VARIATION OF CONDITIONS APPLICATION – LAND TO THE NORTH AND EAST OF WARREN MILL HOUSE, ELMSWELL ROAD, WETHERDEN

PERMISSION TO BE VARIED: DC/22/03101

CONDITIONS TO BE VARIED: 2, 5, 6, 7, 8, 9

DRAWING
BLOCK PLAN & STREET SCENE AS PROPOSED.

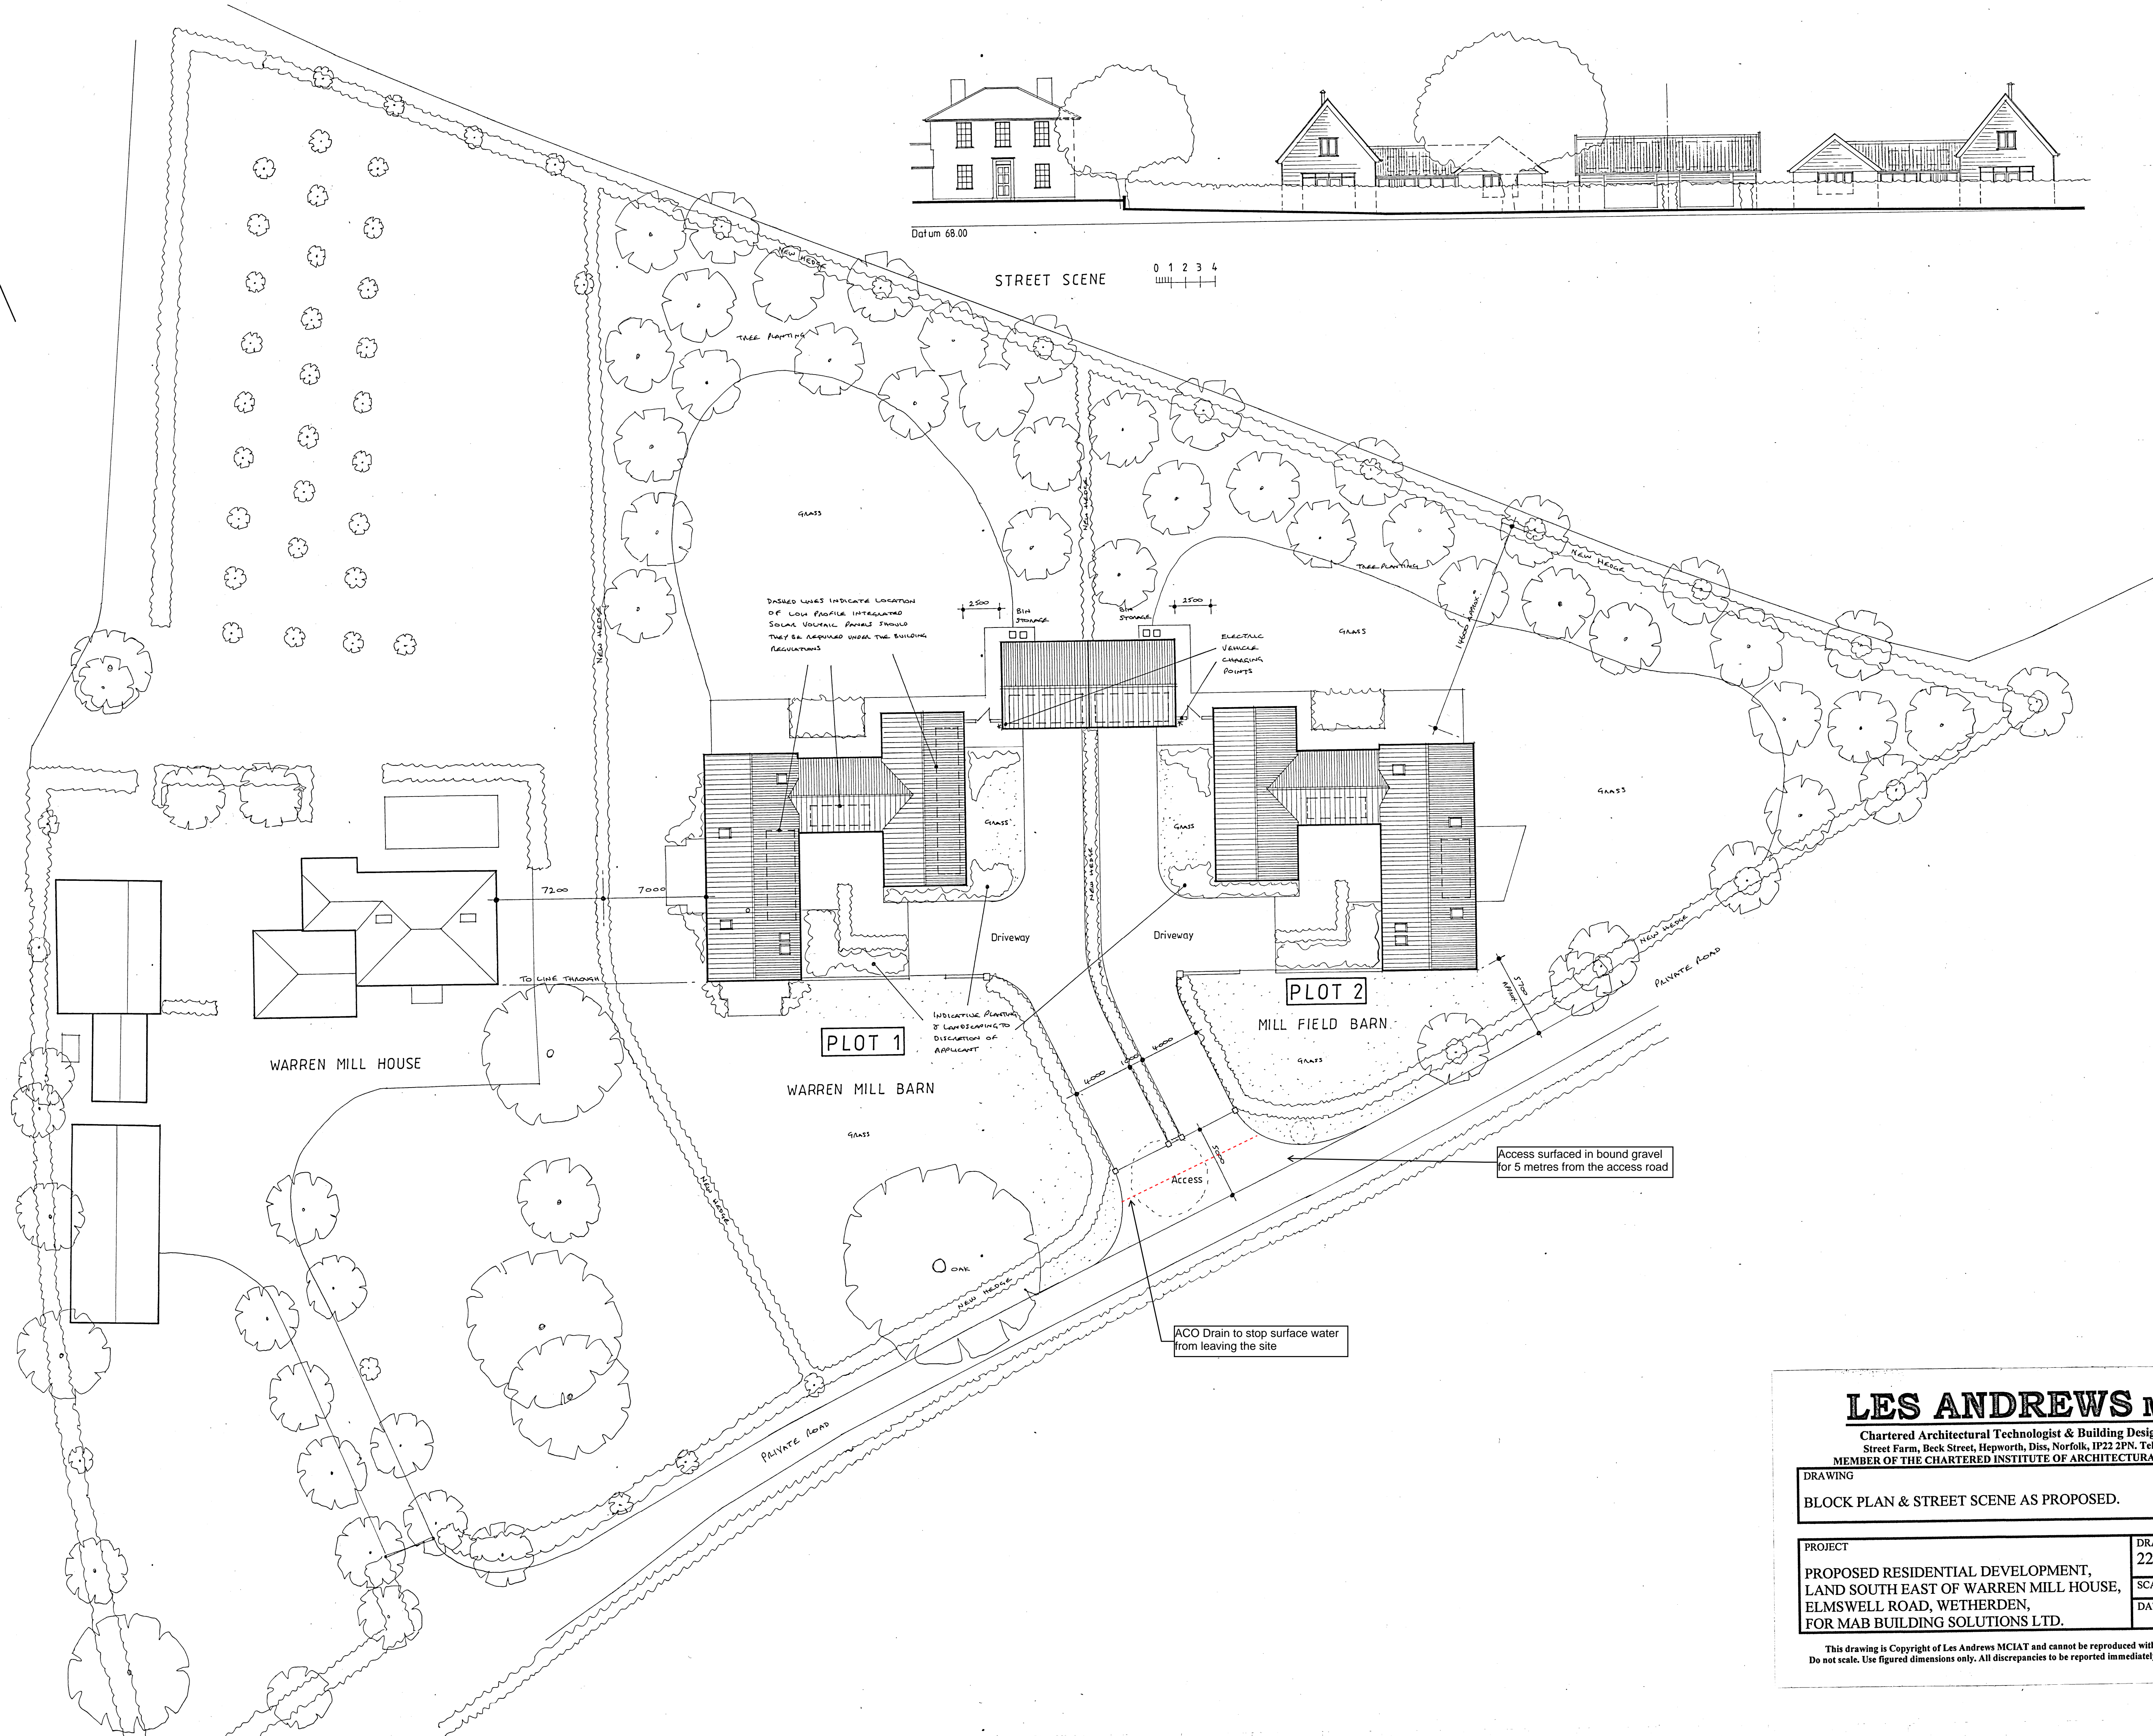
The updated block plan includes separate drives for each of the houses. The access is located in the same area, but the width of each road is now two 4-metre access roads with a 1-metre separating hedge rather than a single 5-metre shared access. The inclusion of the central hedge will reduce the prominence of the access roads which will be more difficult to see from the public footpaths to the east and west of the site.

The proposed garages have also been increased in width by 1.5 metres per garage to provide additional storage space for bicycles and other residential paraphernalia as well as car parking. The height and depth of the garages have not changed.

Figure 2 shows a comparison of the Street Scene from the approved plans and the proposed Street Scene, the character of the development is improved by presenting a more attractive and visually interesting frontage to the plots, especially Plot 2 while remaining subservient and lower than Warren Mill House. As shown in Figure 2, the previously approved frontage of Plot 2 did not present an attractive visual outlook as this lacked any variation. By rotating Plot 2, this means that the principle elevation now looks towards the road which presents a much more attractive frontage. The updated scheme shows varying height gables to the front and differing roof pitches which provide more visual interest.

The impact of the changes on the wider landscape due to the updated design of Plot 2 will be minimal. As shown in Figure 3, the increase in height of the proposed ridge of Plot 2 is modest and the impact of this increase in height is reduced by rotating the house. This means this taller section of the building is perpendicular to the road, reducing the view of it, whereas, on the approved scheme, the highest ridge of Plot 2 ran parallel to the road.

Condition 8 requires that details shall be submitted to, and approved by the Local Planning Authority regarding the first 5 metres of the driveway being surfaced in a bound material. The submitted site plan shows that the access is surfaced with bound gravel for the first 5 metres of the access. Therefore, this condition should be altered as follows;

Condition 9 required that prior to the commencement of works on the access, details preventing surface water discharge from the development onto the highway would be submitted to, and approved in writing by the Local Planning Authority. The updated site plan shows an ACO drain which runs across the front of the access which will prevent any surface water from flowing from the site onto the private road. Therefore, this condition should be altered as follows;

“No other part of the development hereby permitted shall be commenced until the existing vehicular access as shown on Drawing No 2238/01 has been laid out and completed in all respects in accordance with SCC Drawing No DM01 (Standard drawings for vehicular access). Thereafter the access shall be retained in the specified form.”

“Prior to the development hereby permitted being first occupied, the upgraded access shall be properly surfaced with a bound material as shown in the approved plan for a minimum distance of 5 metres”

“Prior to the use of the approved access, the detail submitted to and approved in writing by the Local Planning Authority showing the means to prevent the discharge of surface water from the development onto the access road shall be carried out in its entirety before the access is first used and shall be retained thereafter in its approved form.”
